From: Thomas Callaway
Sent: 23 July 2014 16:51
To: Planning.Responses
Subject: RE: Planning Consultation on: EG/45/14/PL

EG/45/14/PL

Registered: 11th July
2014
Site Address: 17 Elm Grove South Barnham PO22 0EJ
Grid Reference: 495520 104725
Description of Works: Hardstanding for proposed car-park together with air conditioning unit/enclosure, handrail & external lighting

| TITLE<br>SITE PLAN WITH DRAINAGE                                                    |                                                                               |

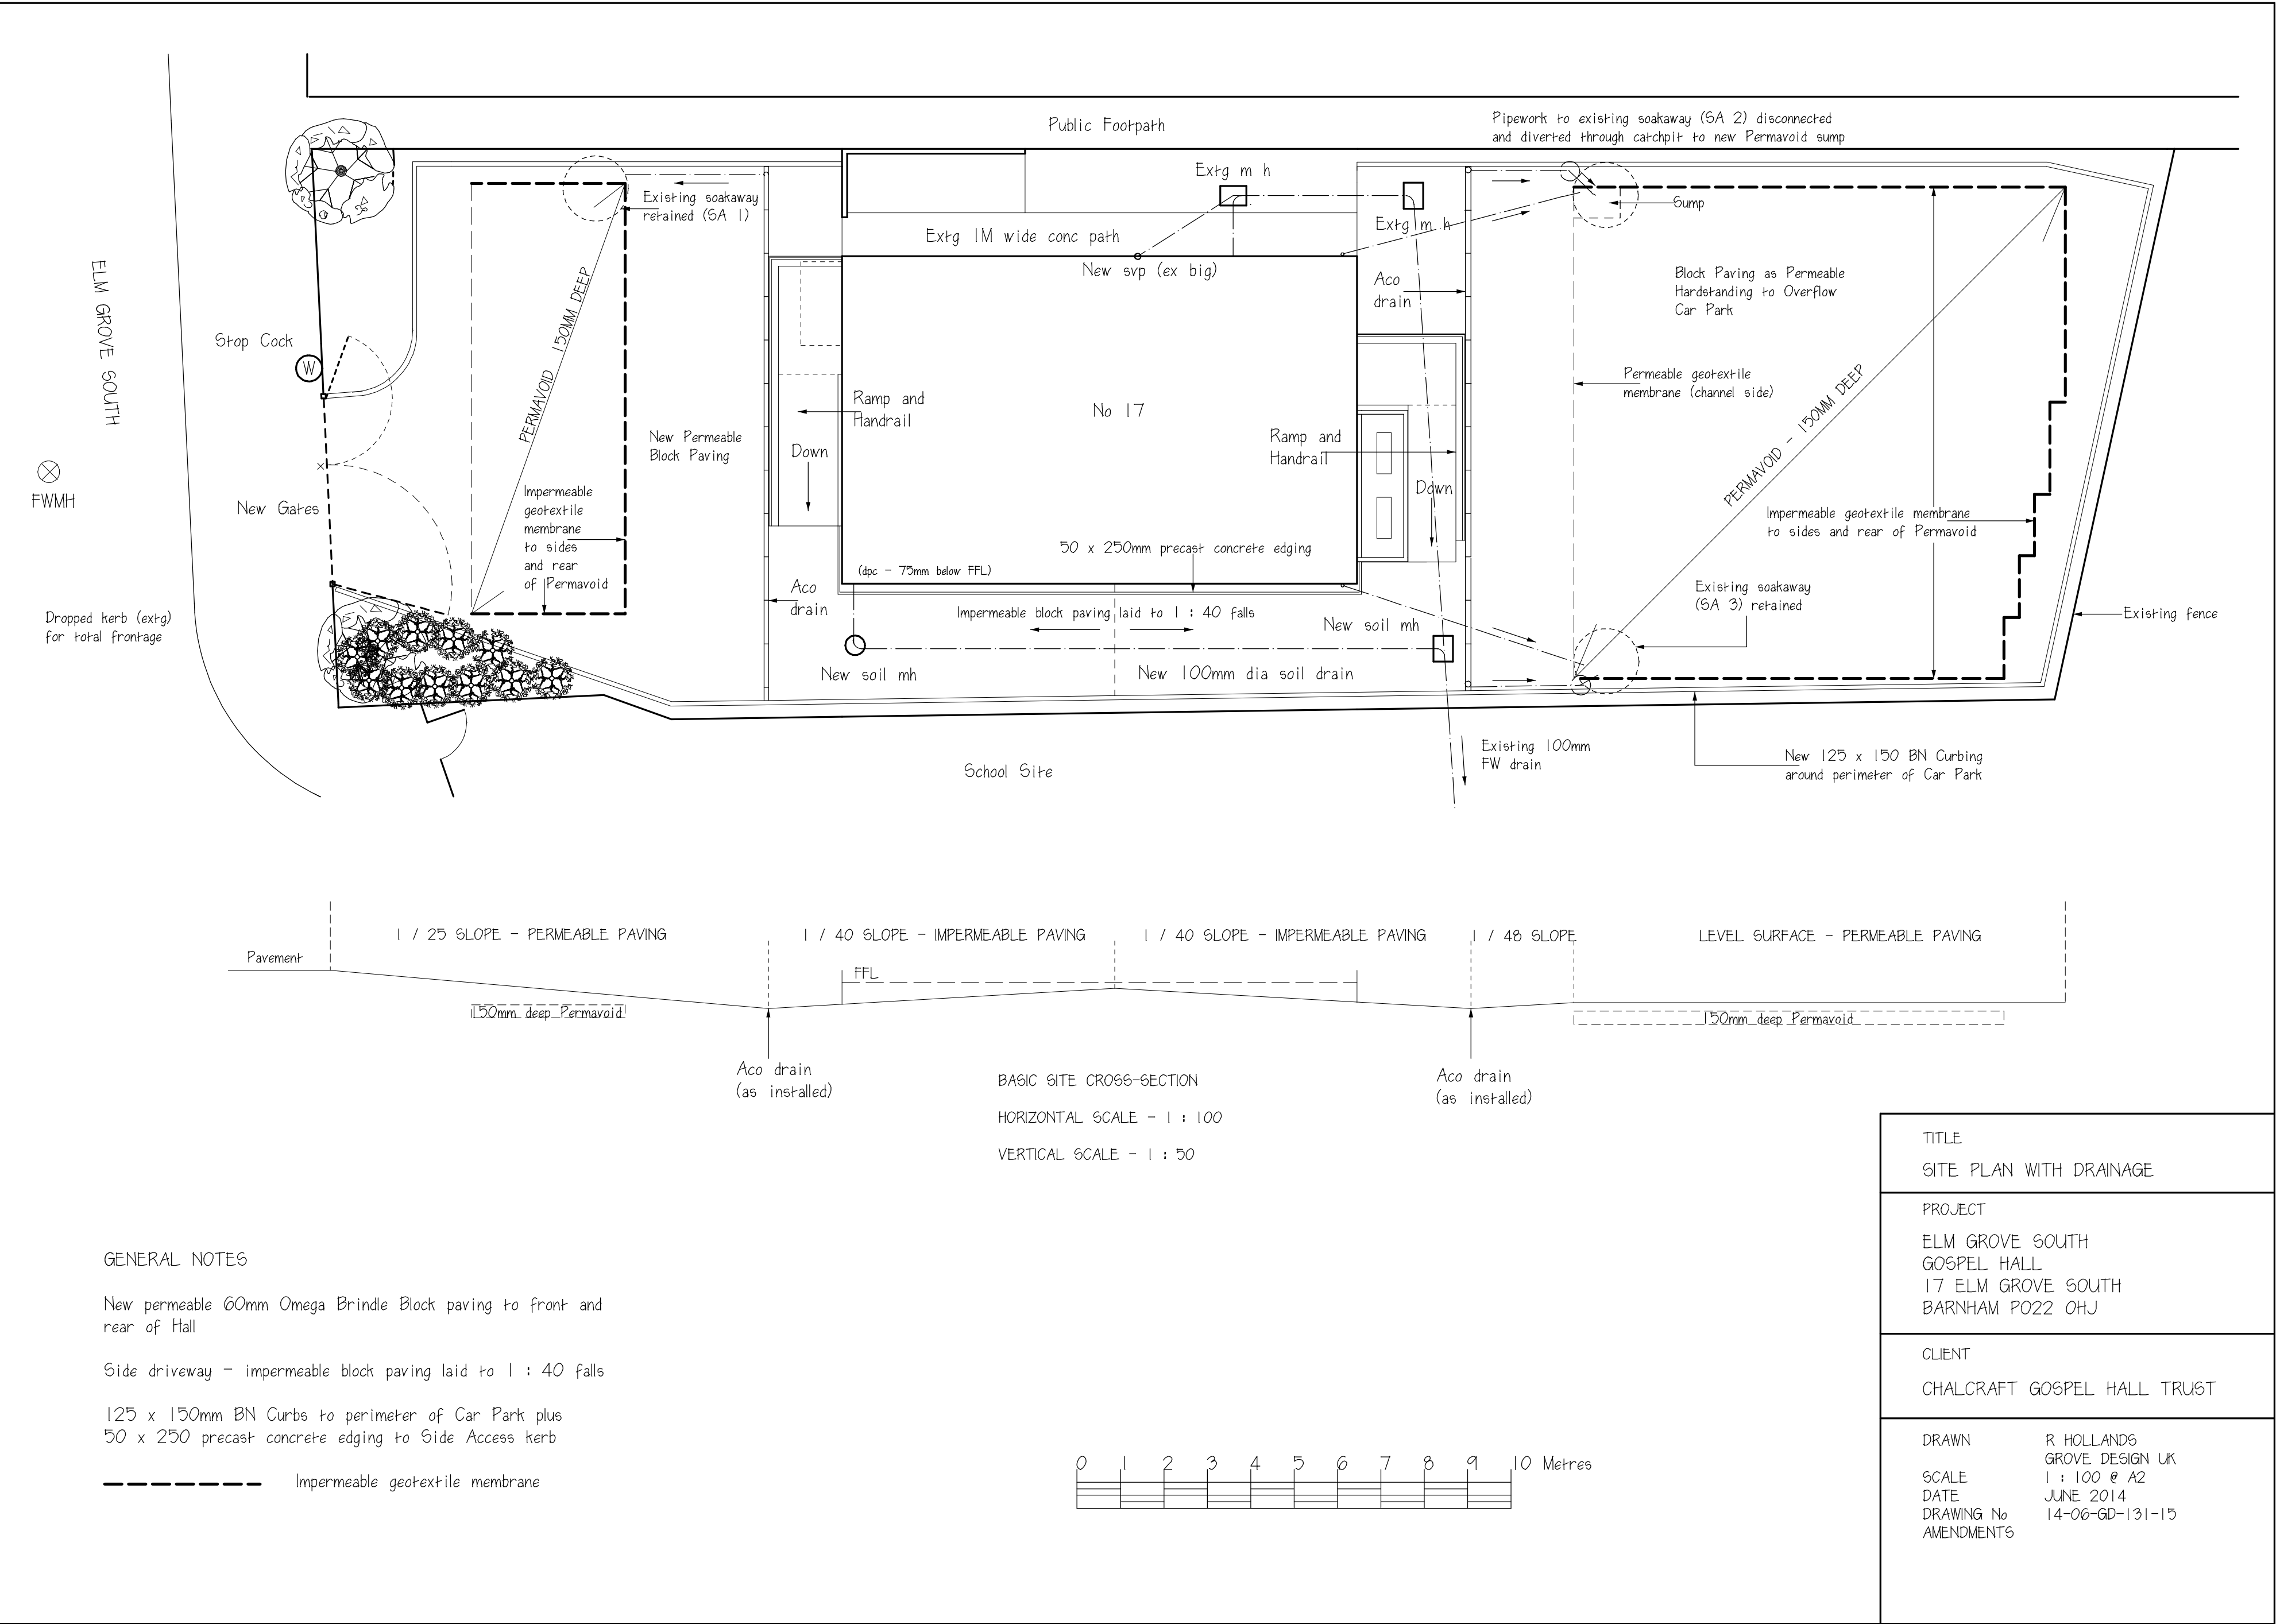
The proposed surface water drainage system has been designed to contain the 1 in 100 year storm event plus 30%, and to store it above the highest recorded groundwater level so that all storage will be available in times of high water table. The edges of the parking areas are to be kerbed so that water does not infiltrate laterally and is contained on site.

The proposed surface water drainage system is acceptable.
